Rezoning Petition Review

Date of Review: May 20, 2020 (***Revised February 24, 2021***)

Rezoning Petition #: 20-68

Location of Property: Approximately 8.5 acres located along the east and west side of Hedgemore Rd, south of Woodlawn Rd and west of Selwyn Ave.

SCHEMATIC SITE PLAN
PETITION # 2020-068
FOR
HEDGEAMORE - MONTFORD PARK
CHARLOTTE, NORTH CAROLINA 28209

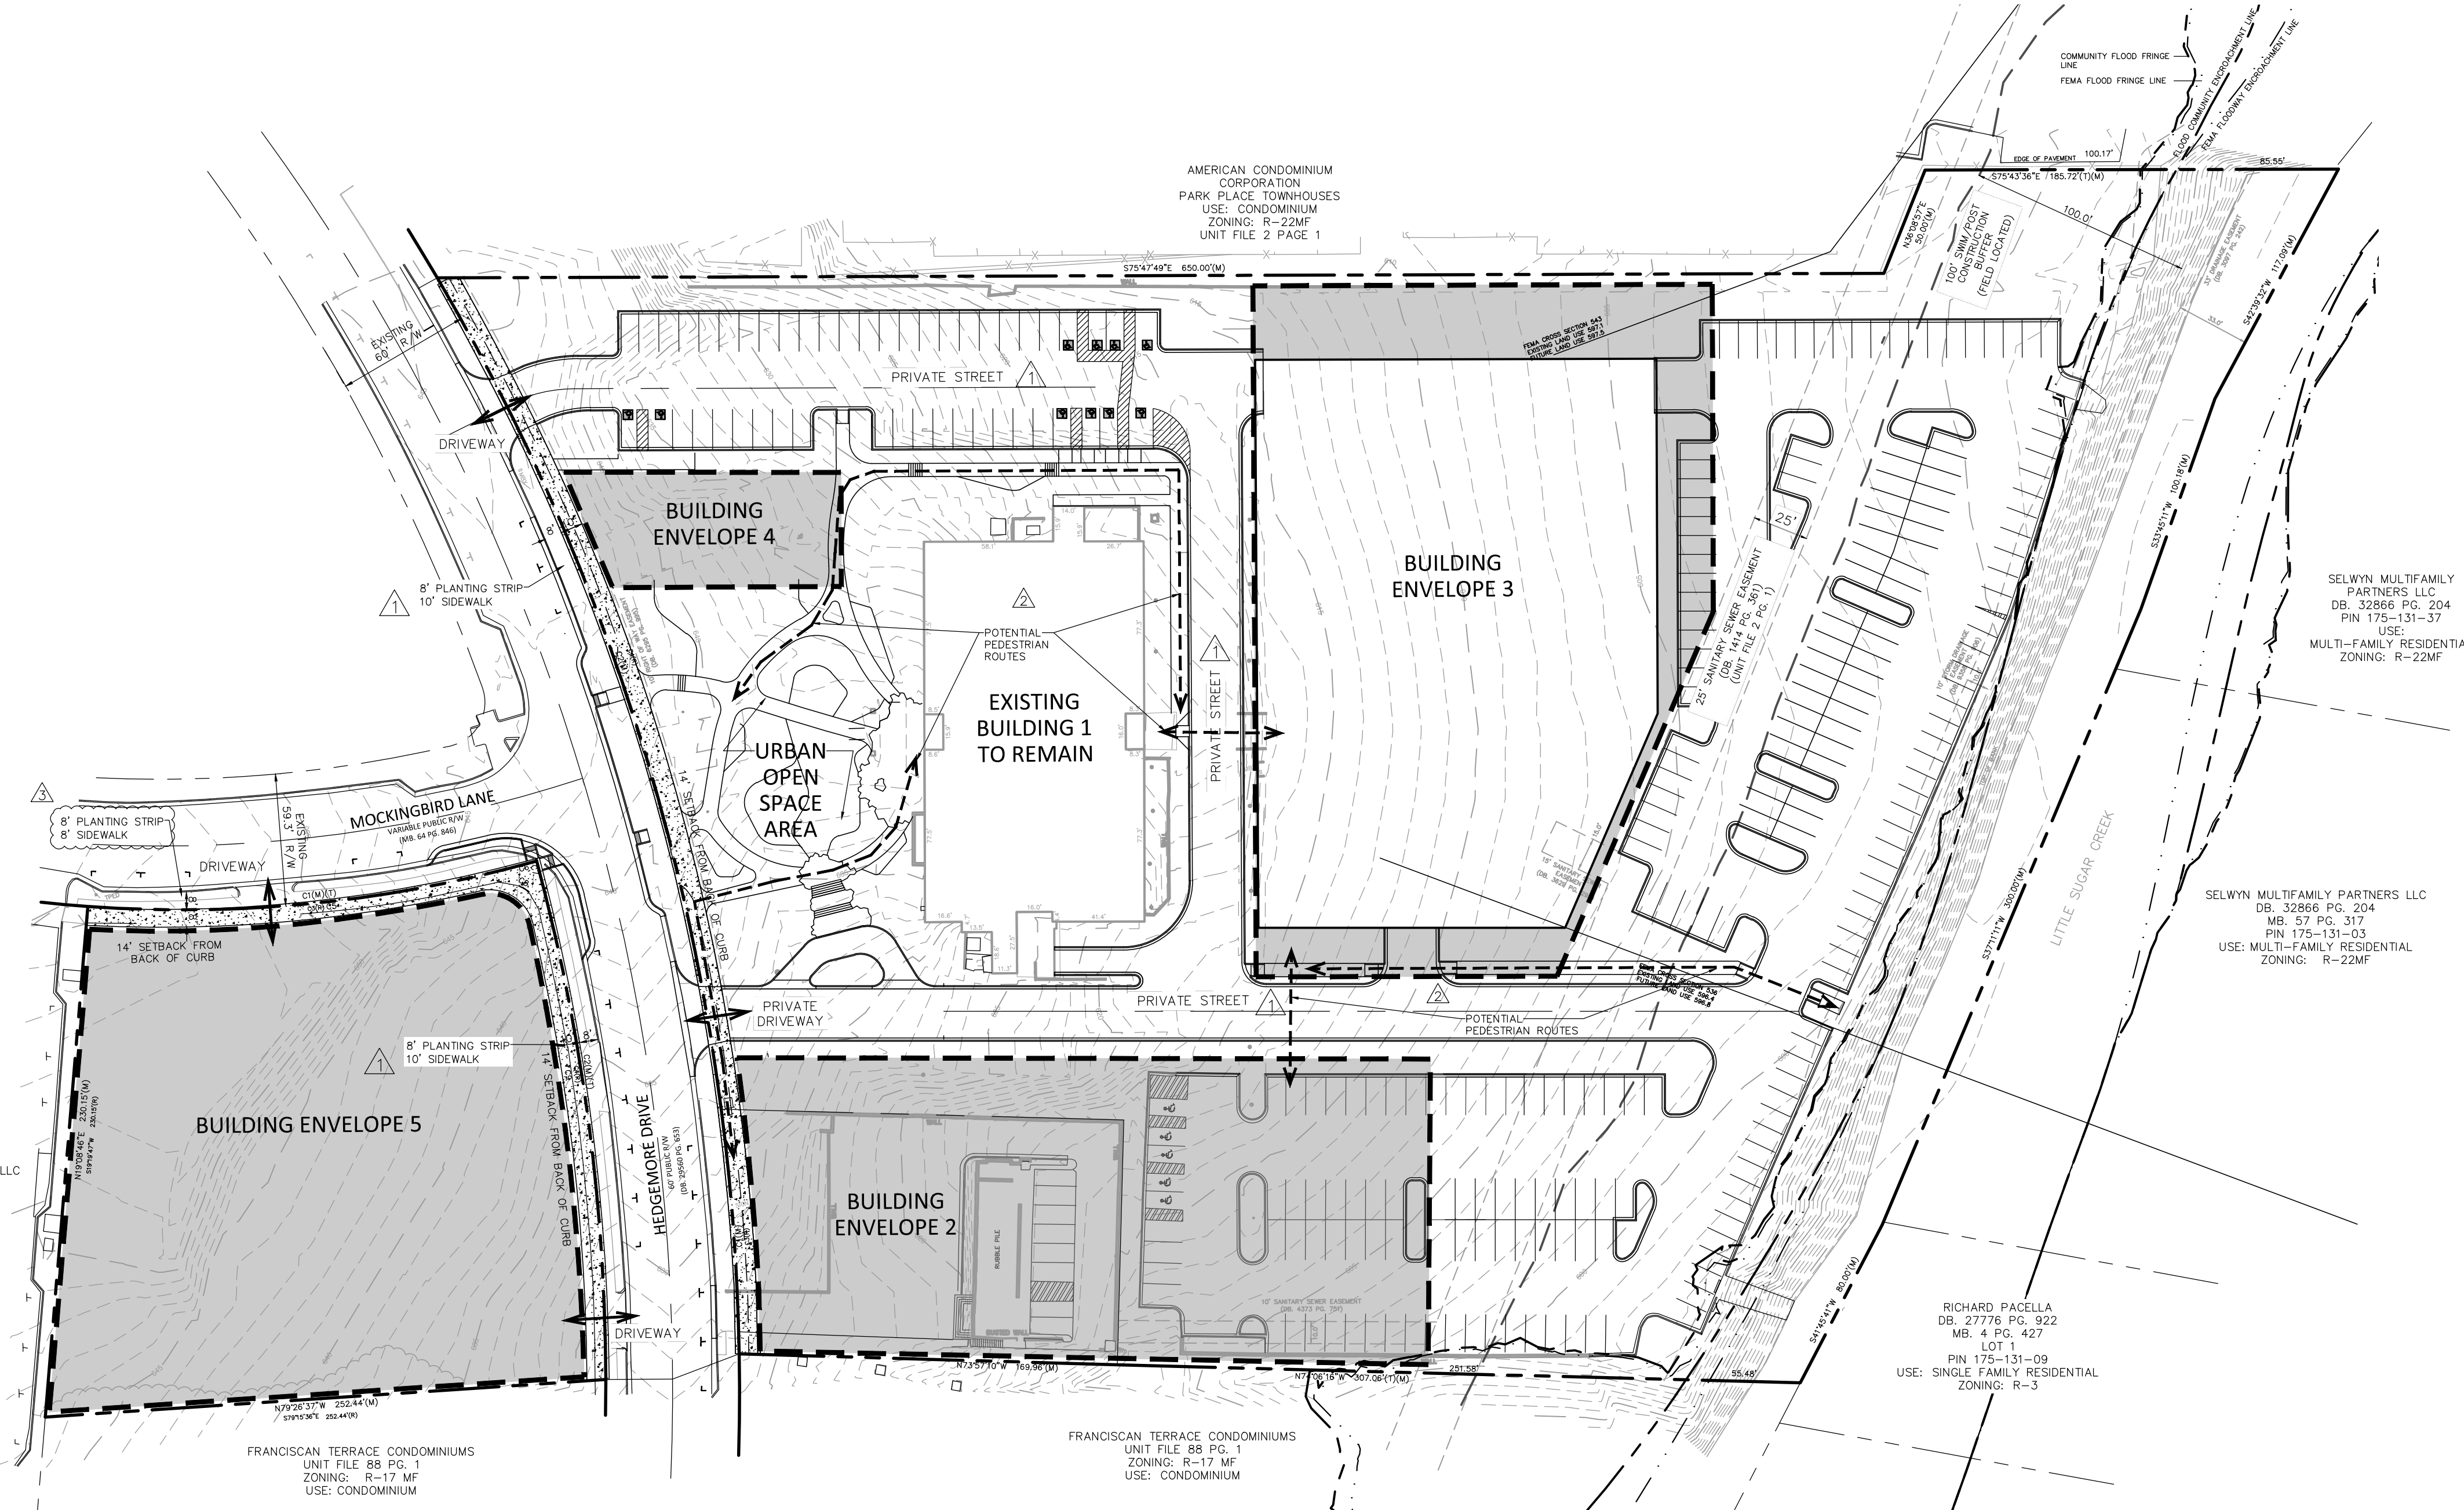
Please remove note "b" under *Environmental Features* in its entirety and replace with the following note: *Development within the SWIM/PCSO Buffer shall be coordinated with and subject to approval by Charlotte-Mecklenburg Storm Water Services and mitigated if required by City ordinance. Please note Stream Delineation Reports are subject to review and approval by Charlotte Storm Water Services.*

This property drains to Upper Little Sugar Creek, which is an impaired/degraded stream, and may contribute to downstream flooding. This project has the opportunity to mitigate future impacts to this stream, therefore, Storm Water recommends placing the following notes on the plan:

(I) Storm Water Quality Treatment

For defined watersheds greater than 24% built-upon area (BUA), construct water quality stormwater control measures (SCMs) designed for the runoff generated from the first 1-inch of rainfall for all new and redeveloped BUA associated with the project. SCMs must be designed and constructed in accordance with the Charlotte-Mecklenburg BMP Design Manual.

(II) Volume and Peak Control

For defined watersheds greater than 24% built-upon area, control the entire volume for the 1-year, 24-hour storm for all new and redeveloped BUA associated with the project. Runoff volume drawdown time shall be in accordance with the Charlotte-Mecklenburg BMP Design Manual.

For commercial projects with greater than 24% BUA, control the peak to not exceed the predevelopment runoff rates for the 10-yr, 6-hr storm and perform a downstream flood analysis to determine whether additional peak control is needed and if so, for what level of storm frequency, or if a downstream analysis is not performed, control the peak for the 10-yr and 25-yr, 6-hour storms.

For residential projects with greater than 24% BUA, control the peak to not exceed the predevelopment runoff rates for the 10-year and 25-year, 6-hour storms or perform a downstream analysis to determine whether peak control is needed, and if so, for what level of storm frequency.
